Subject: Response to EES comments in respect of SSD-8640 MOD 3

I refer to comments received from the EESG dated 28 October 2021, prepared in response to Picton High School MOD 3. This correspondence has been prepared to clarify the matters raised in the aforementioned correspondence.

Condition 36(d) – Native tree hollows and tree trunks

Native tree stump habitat locations

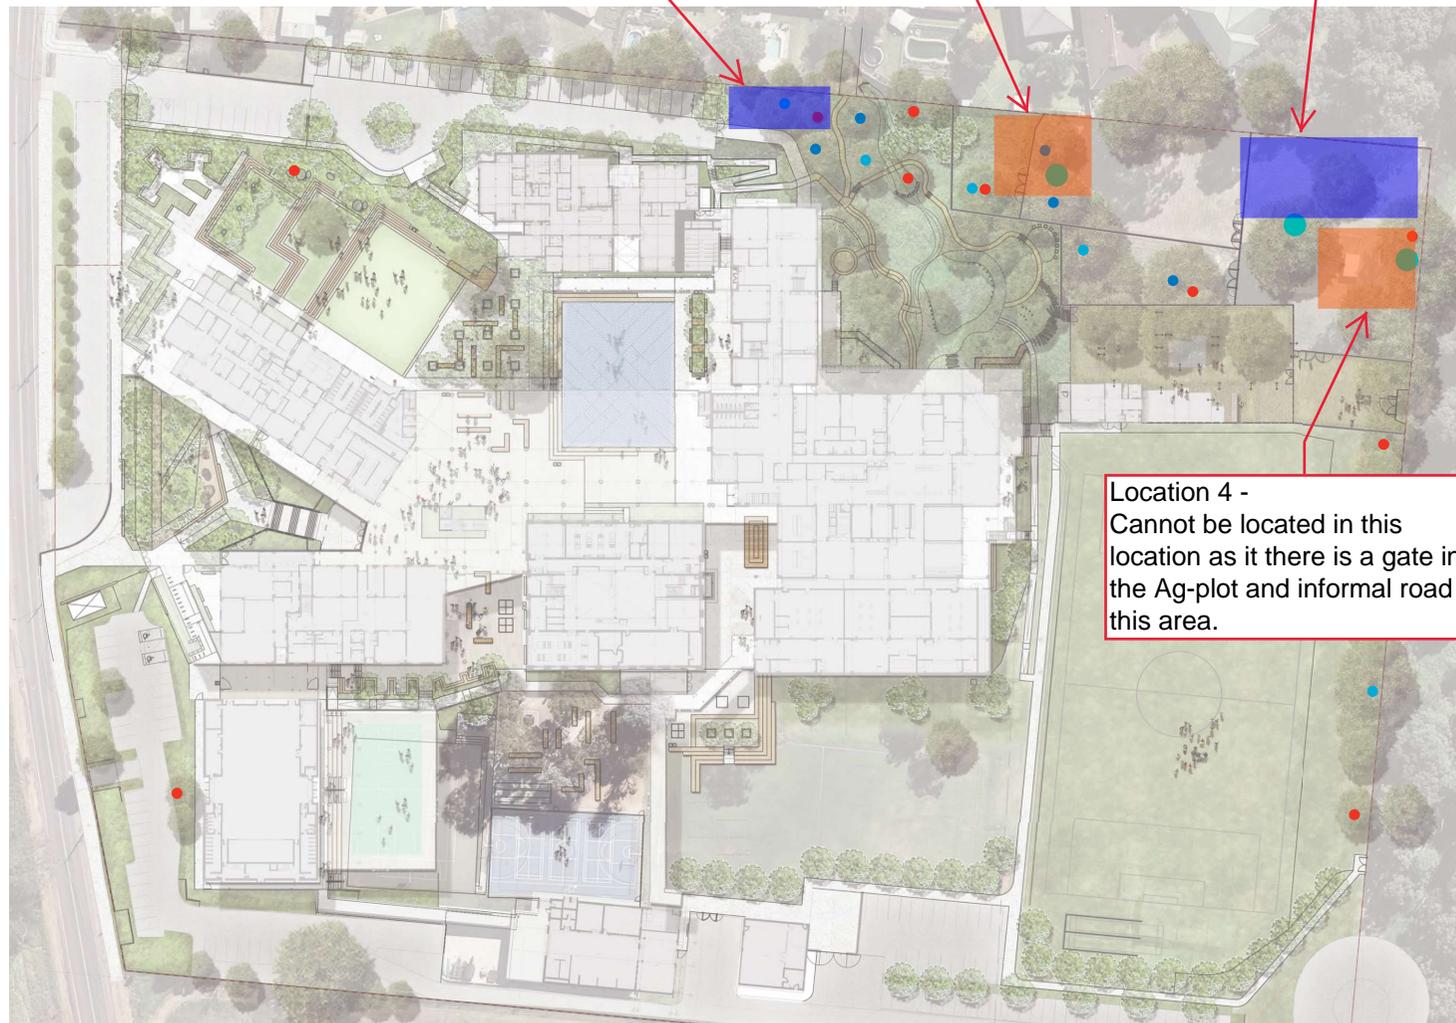
EES identified an inconsistency within Attachment 3 of the documentation, noting that there are three locations proposed in the Agriculture Precinct identified for felled native tree habitat provision. This related to the original report 'Landscape Management Plan', issue No.4 dated April prepared by Arcadia. Upon further investigation by the Project Team, two of the locations that were originally identified have been deemed as impractical when considering the design holistically and consulting the school in relation to its operational requirements. Accordingly, the Project team identified 2 alternate locations that will satisfy the requirements of all stakeholders, which are detailed in the revised mark-up (**Attachment 1**) to provide further clarity.

We also confirm that the current target is to place the 20 tree trunks at the school site by 1 June 2022. The reference to 2021 is a typographical error.
